From: Jennifer Ballinger
Sent: 03 July 2020 16:00
To: Gemma Magnuson
Subject: RE: 20/01196/F & 20/01260/LB - The Old Post Office

Jenny Ballinger
Senior Conservation Officer
Planning Policy, Conservation and Design
Cherwell District Council

Scale:
 1:100 @ A3
 Number:
 200_Rev.D

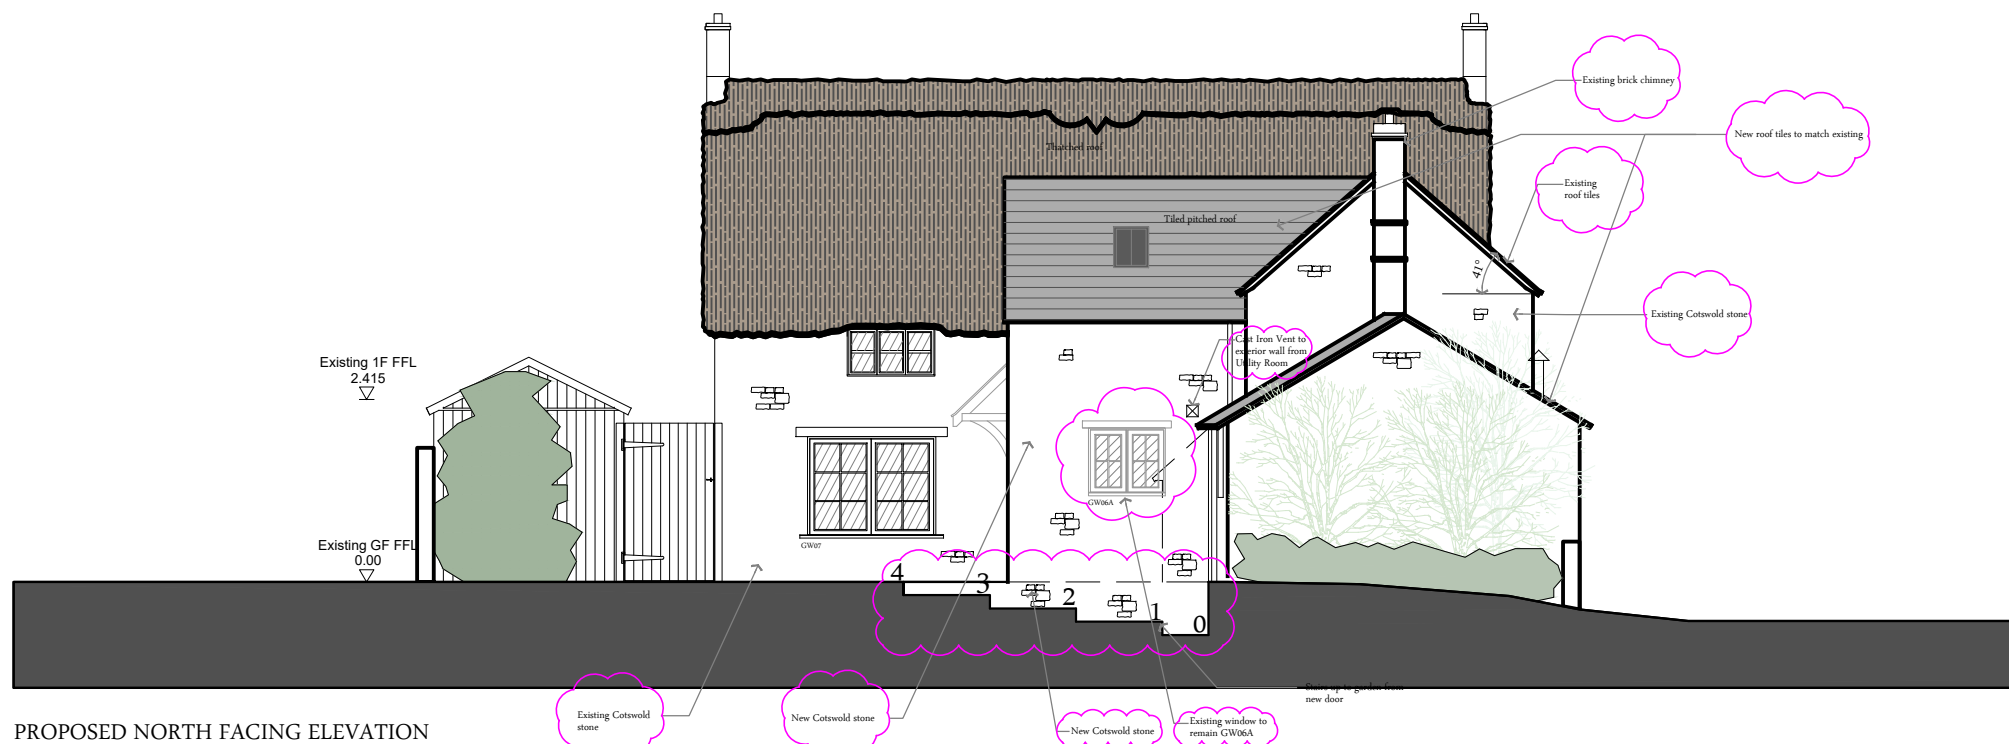
There are no particular objections to the minor alterations to the plans. A stone sample panel will be required for the wall and further details of the proposed vent will need to be provided.

These can be dealt with by condition if necessary.
